CITY OF ALBUQUERQUE

**RE: McDonanlds
301 Eubank Blvd SE
Grading and Drainage Plan
Engineer's Stamp Date: 3/5/25
Hydrology File: L20D004A
Case # HYDR-2025-00087**

Based upon the information provided in your submittal received 03/18/2025, the Grading & Drainage Plans are not approved for Building Permit, and Grading Permit. The following comments need to be addressed for approval of the above referenced project:

301 EUBANK BLVD ALBUQUERQUE, NM	DRAWN BY pm
	CONCEPTUAL GRADING AND DRAINAGE PLAN	DATE 4-3-25
	 5571 MIDWAY PARK PL. NE ALBUQUERQUE, NEW MEXICO 87109 (505) 858-3100 www.tierrawestllc.com	DRAWING 2024052-GR
		SHEET # GR-1 JOB # 2024052

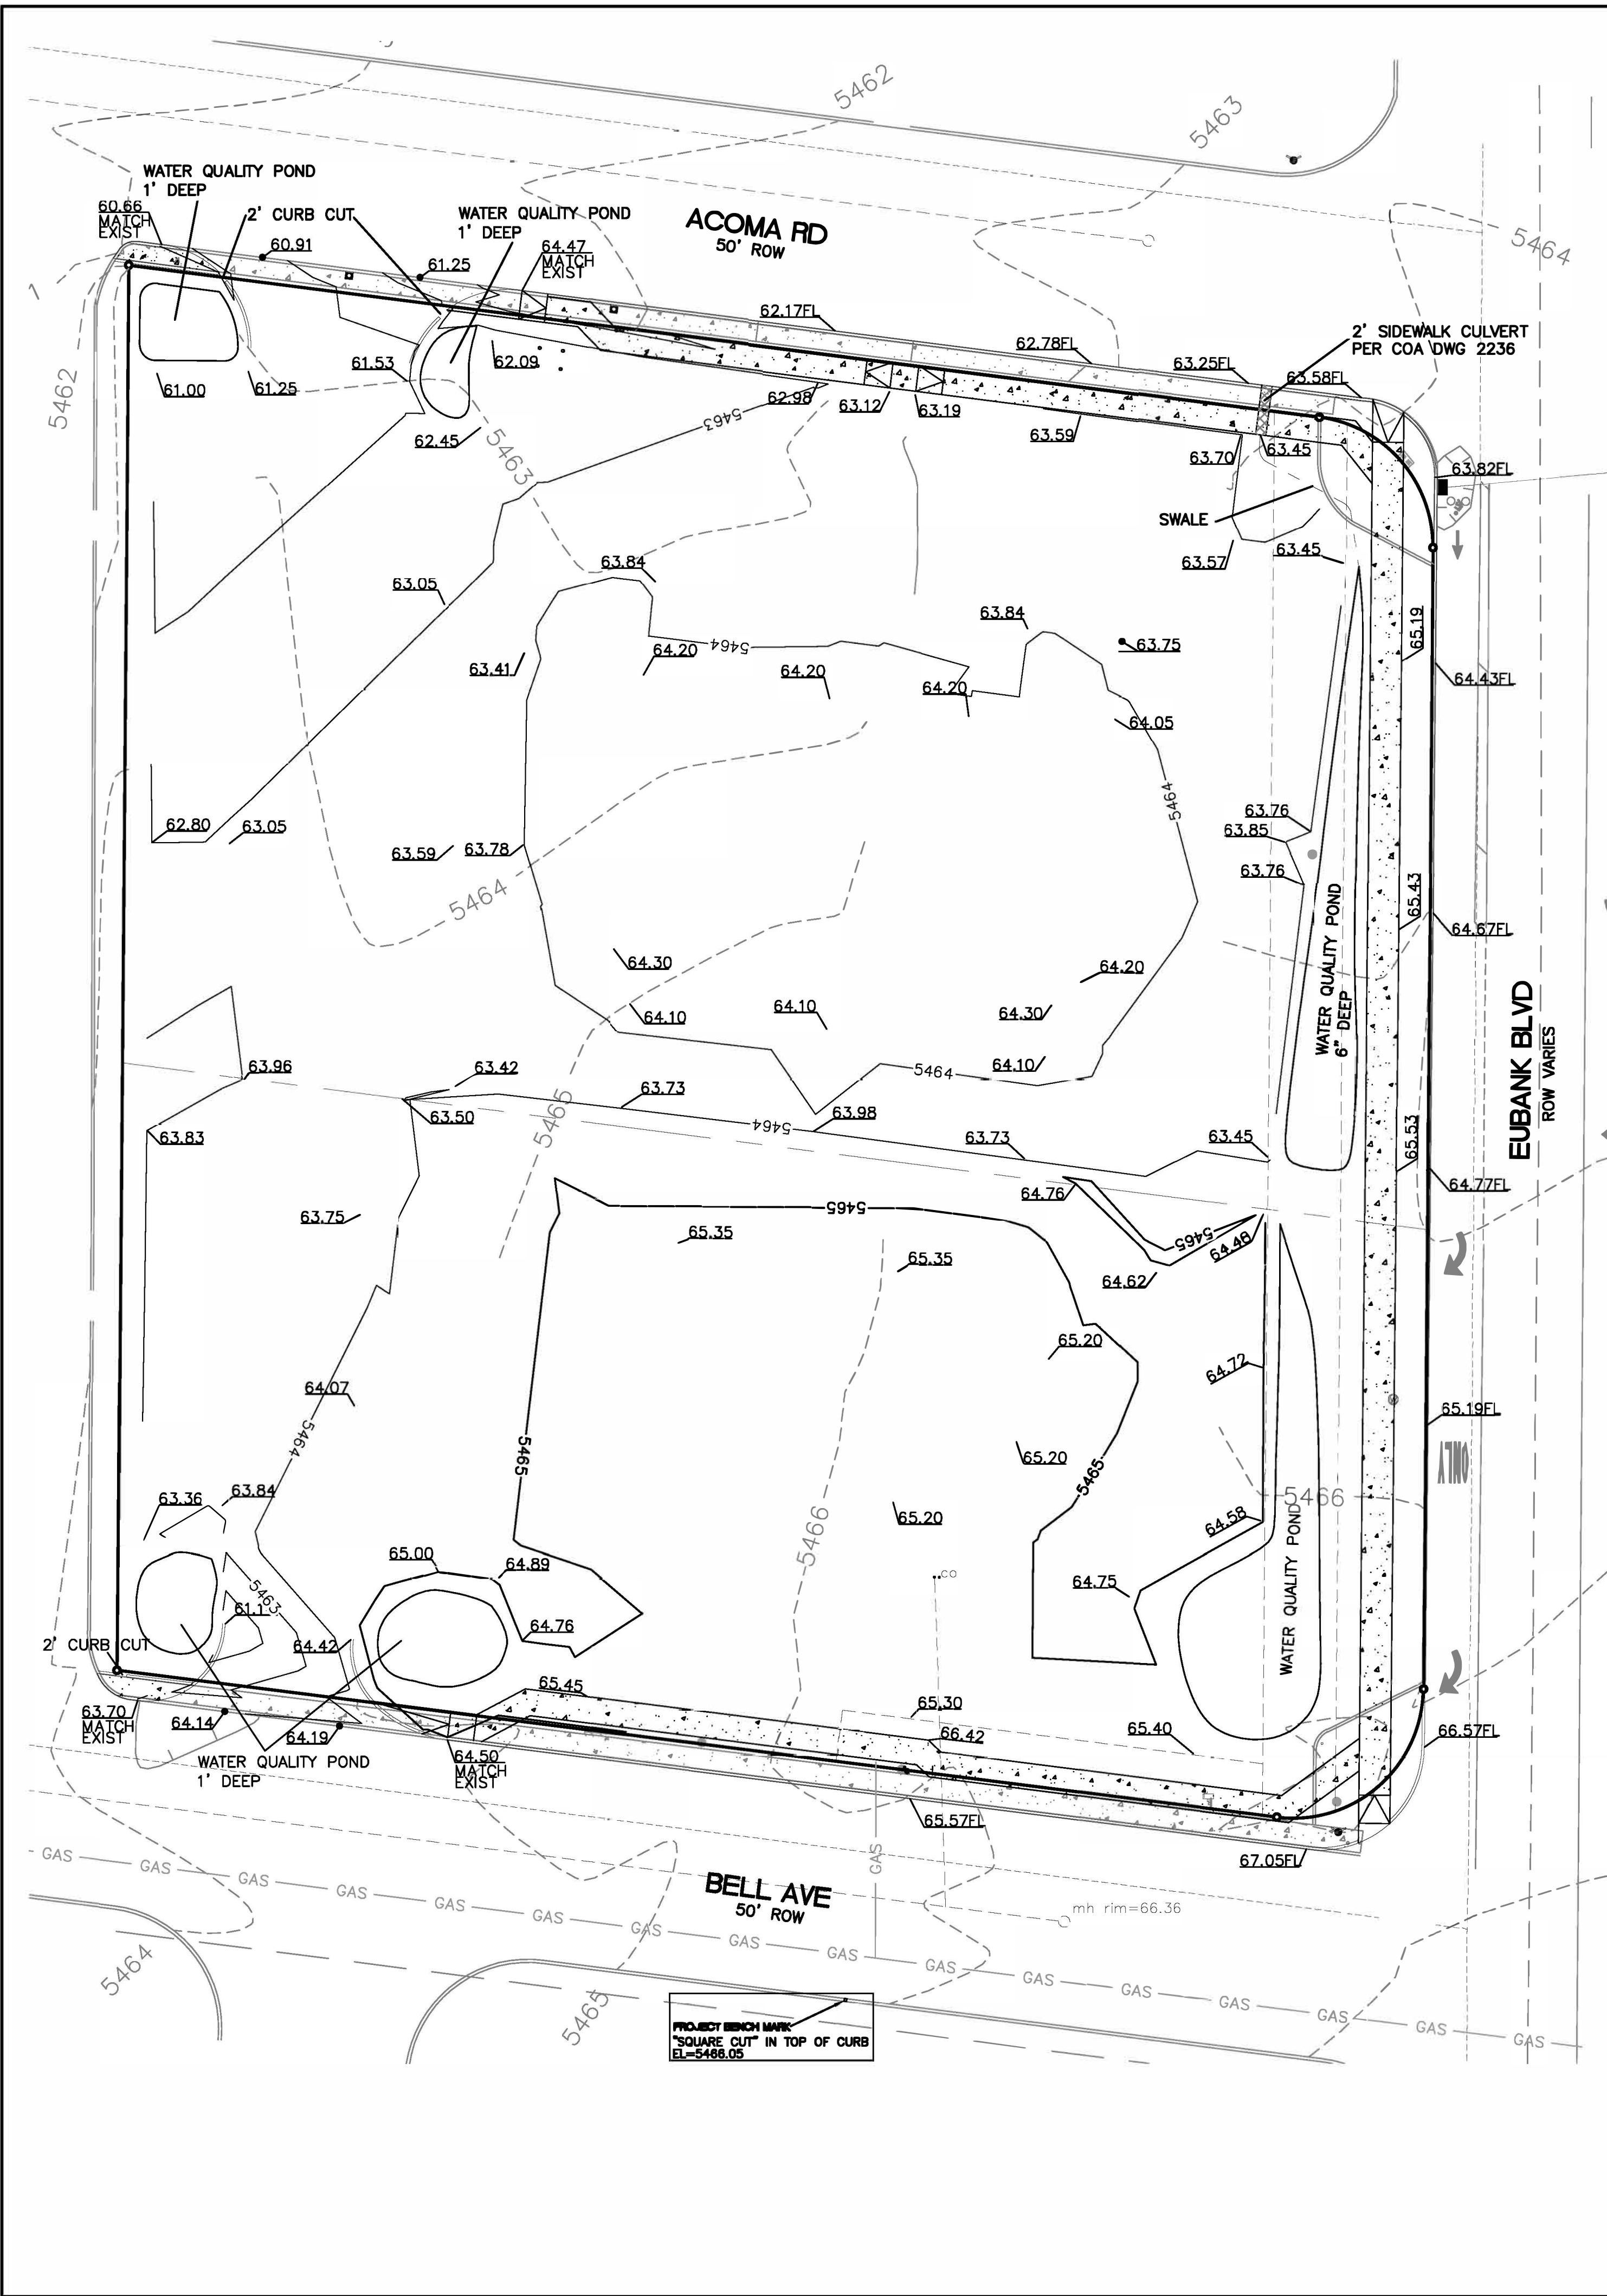
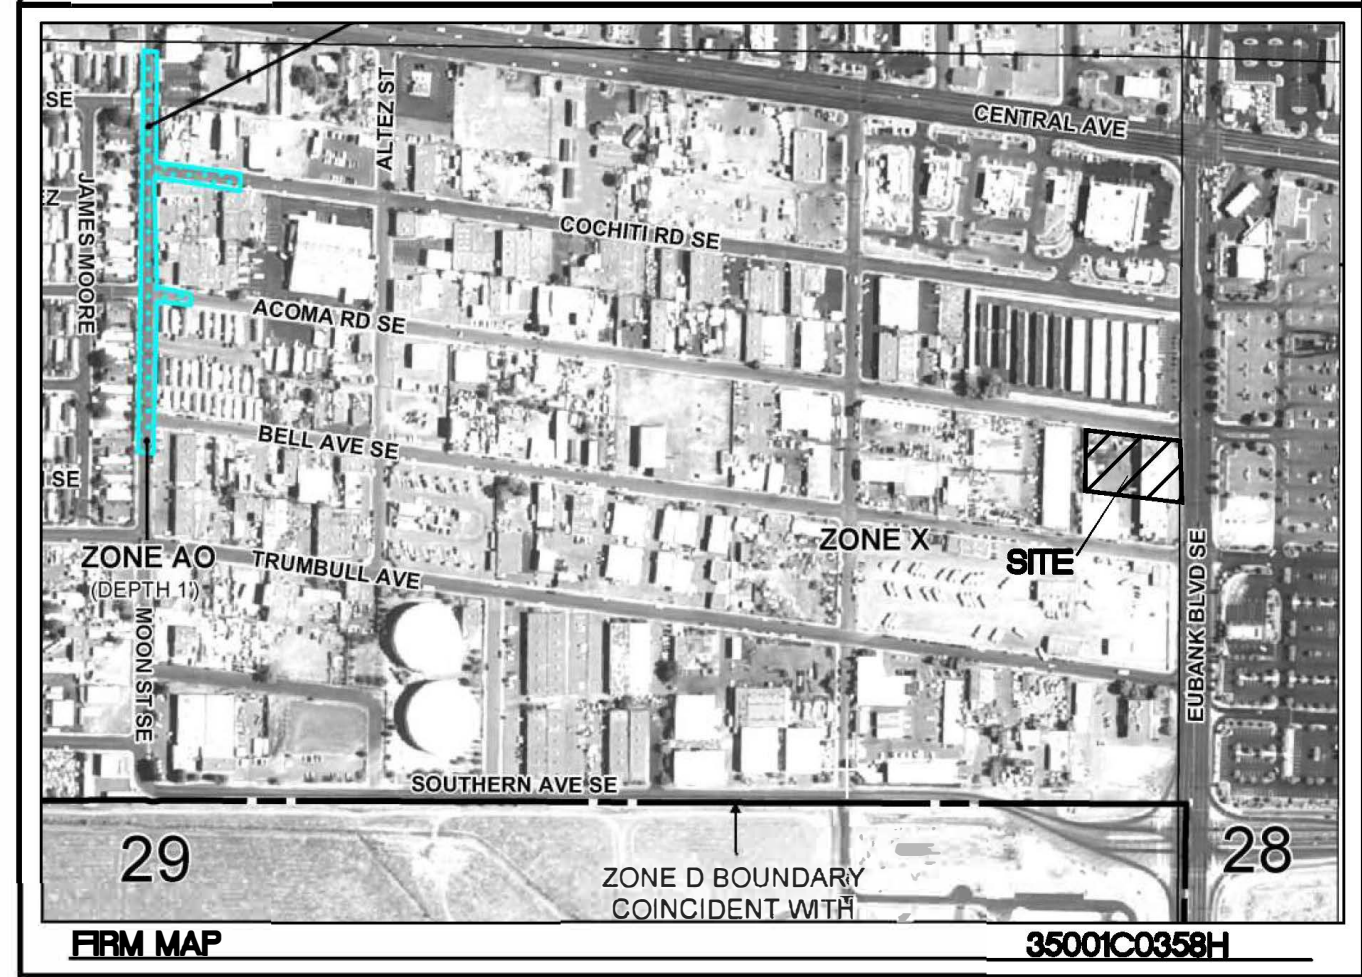
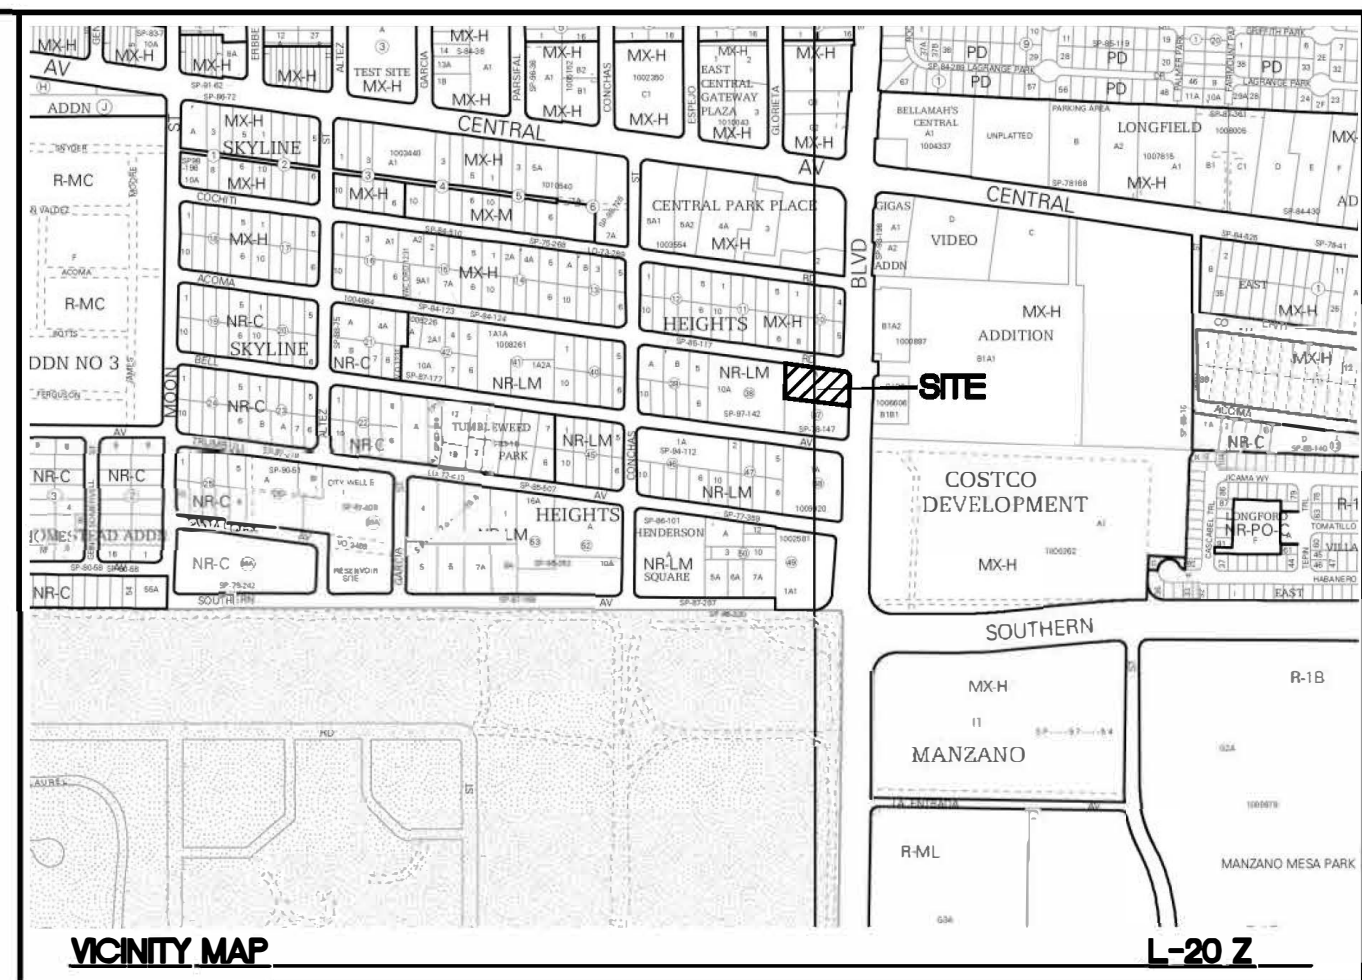
1. An SO-19 Permit will be required and should be included on the request. Please include the [standard SO-19](#) notes on the grading plan.
2. Please show the Stormwater Quality volume provided within each pond along with the water surface elevation of the SWQ volume in a chart.
3. Include project benchmark and datum.
4. Please provide the legal description of the property.
5. For trash enclosures serving food service developments, trash enclosures must demonstrate control of liquids from dumpster areas per DPM by containing runoff from the dumpster area, preventing outside drainage from entering the dumpster area, and discharging to the sanitary sewer. Please show an inlet in the middle and label. "Inlet to be connected to the sanitary sewer. See Utility Plan."
